Subject: FG/220/18

The latest report on this application states that there will be no change to the pond area and resubmitted plans show a clear area all round the pond.

EXISTING POND ACCESS
PLAN

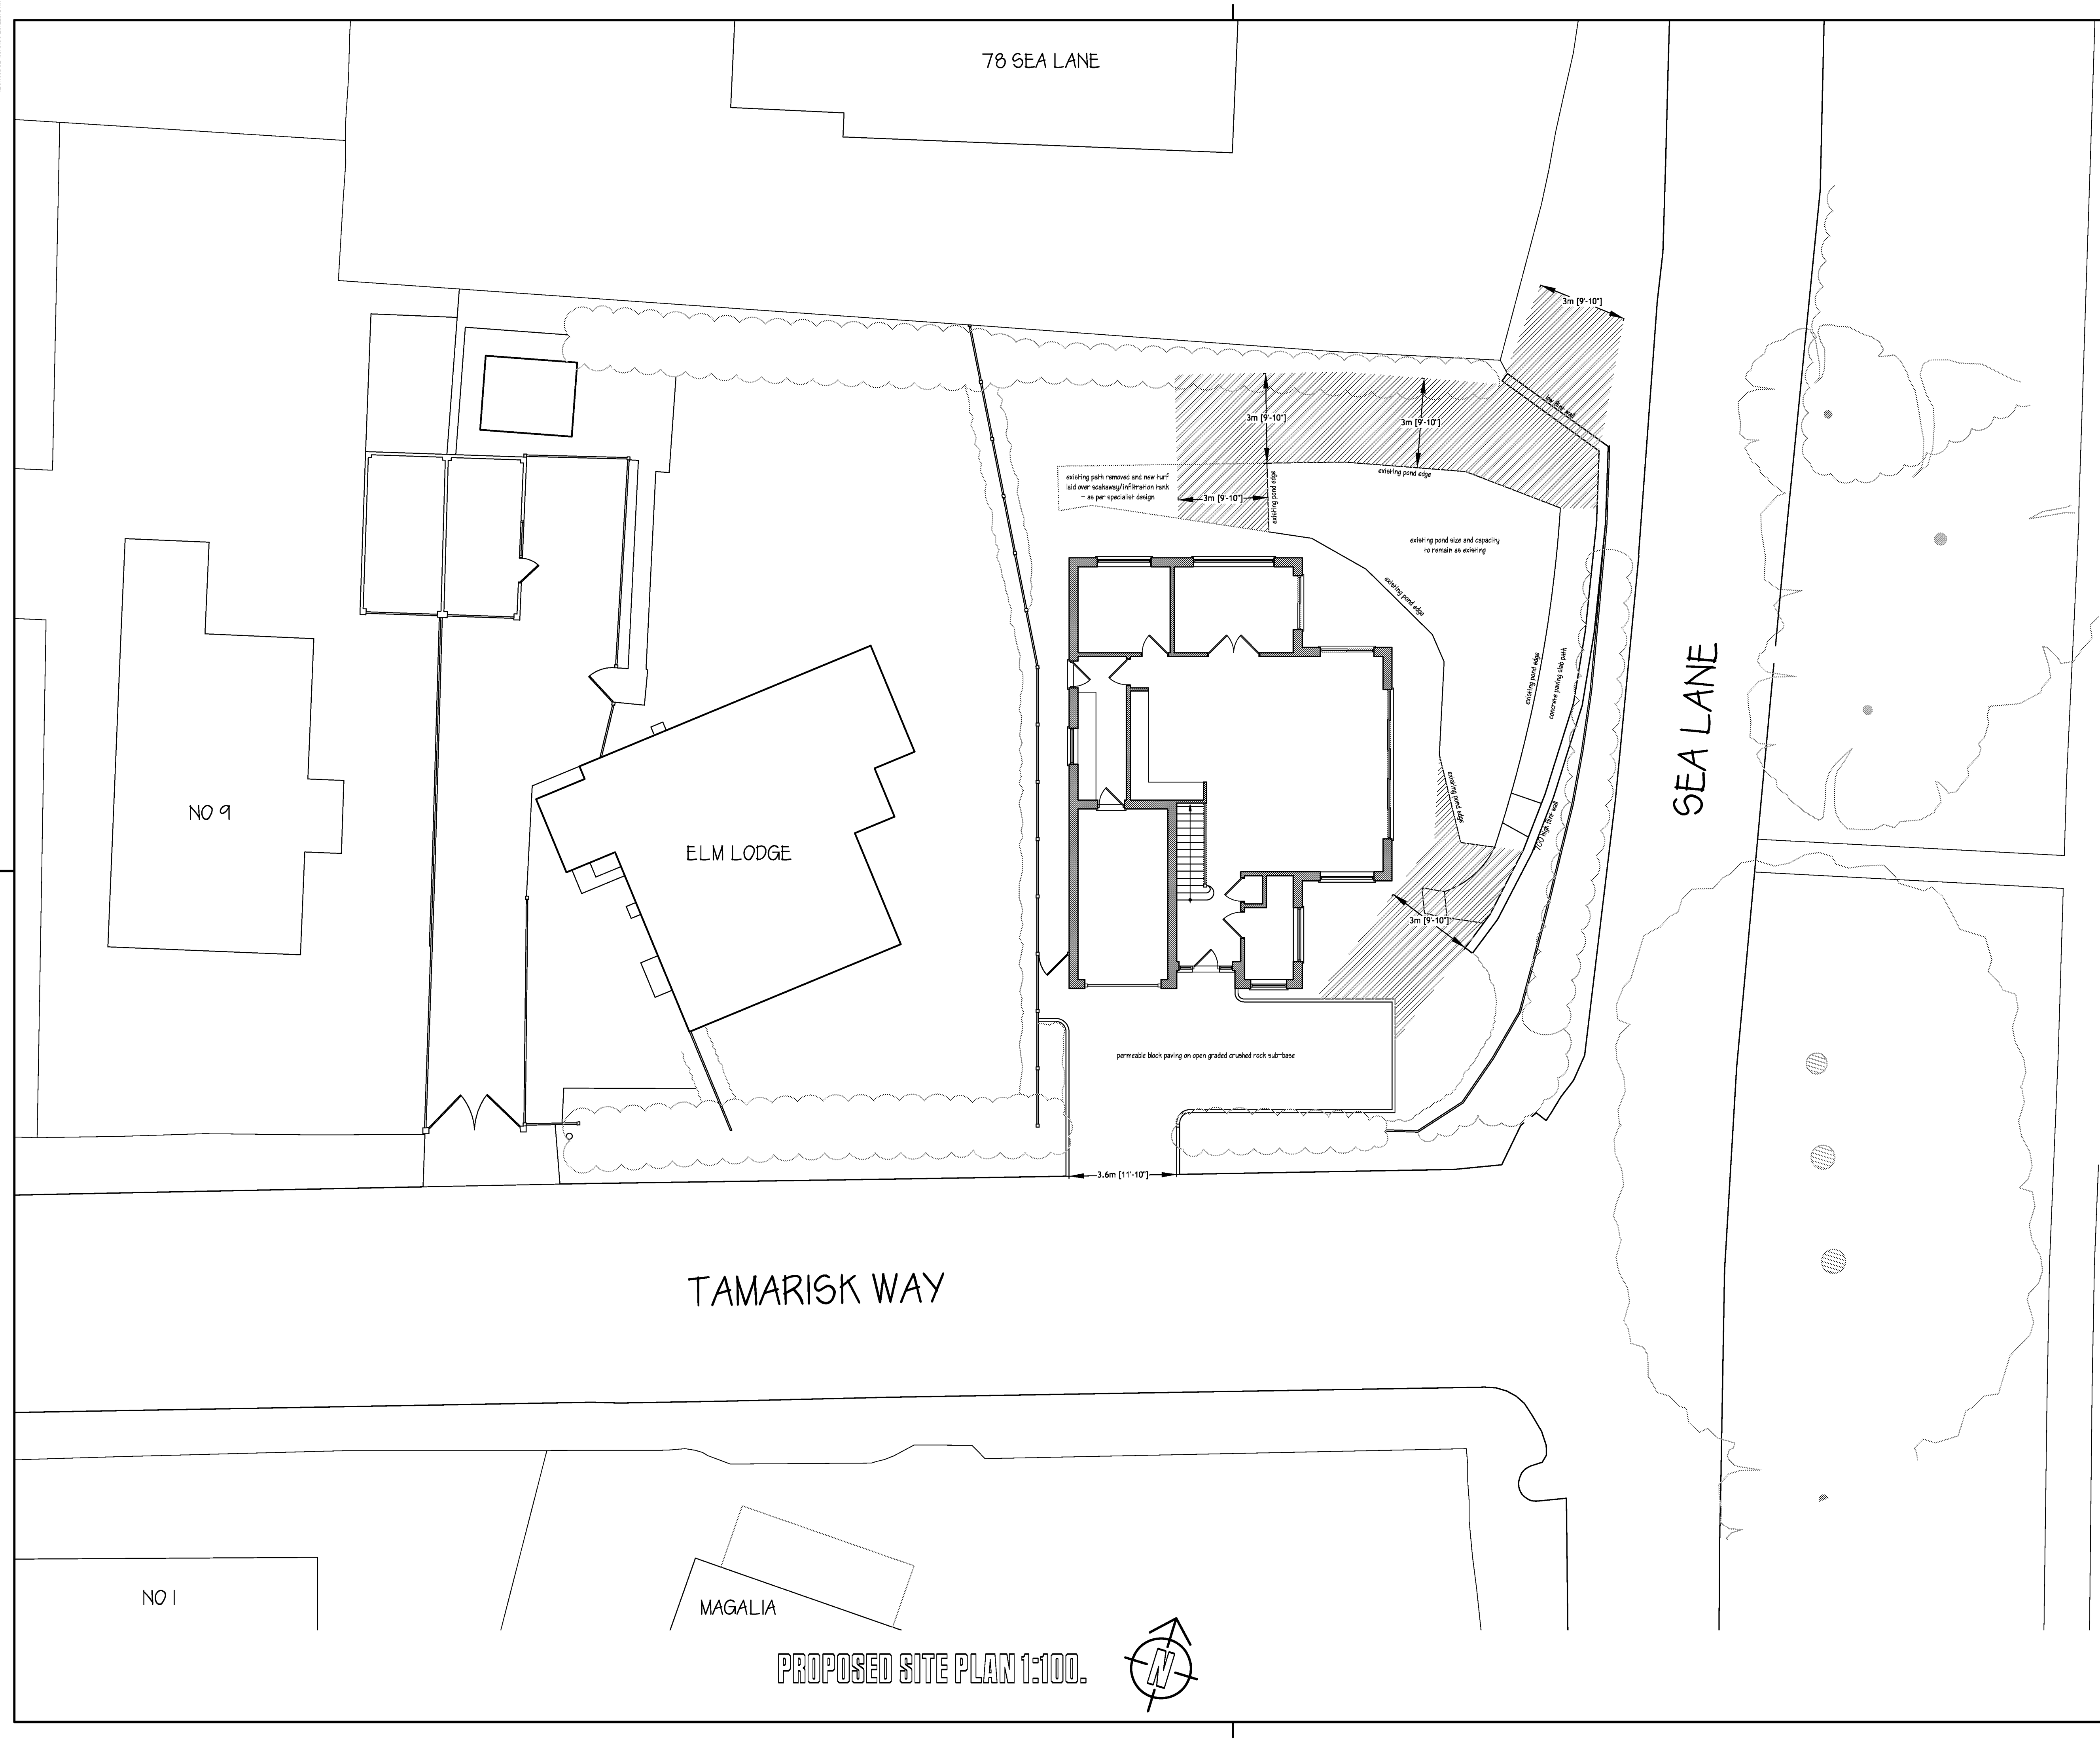
However, the pond area extends fully to the boundary wall on the NE corner of the plot, allowing no easement(ref Laura Gibbons report). The extent of the pond is clearly illustrated in the attached photos and on the land registry document already submitted. This further suggests that not withstanding small adjustments to the siting of the new building, there is no alleviation to the threat to the drainage system.

We would suggest that this, combined with the large size of the pond, severely restricts the amount of land available to build on.
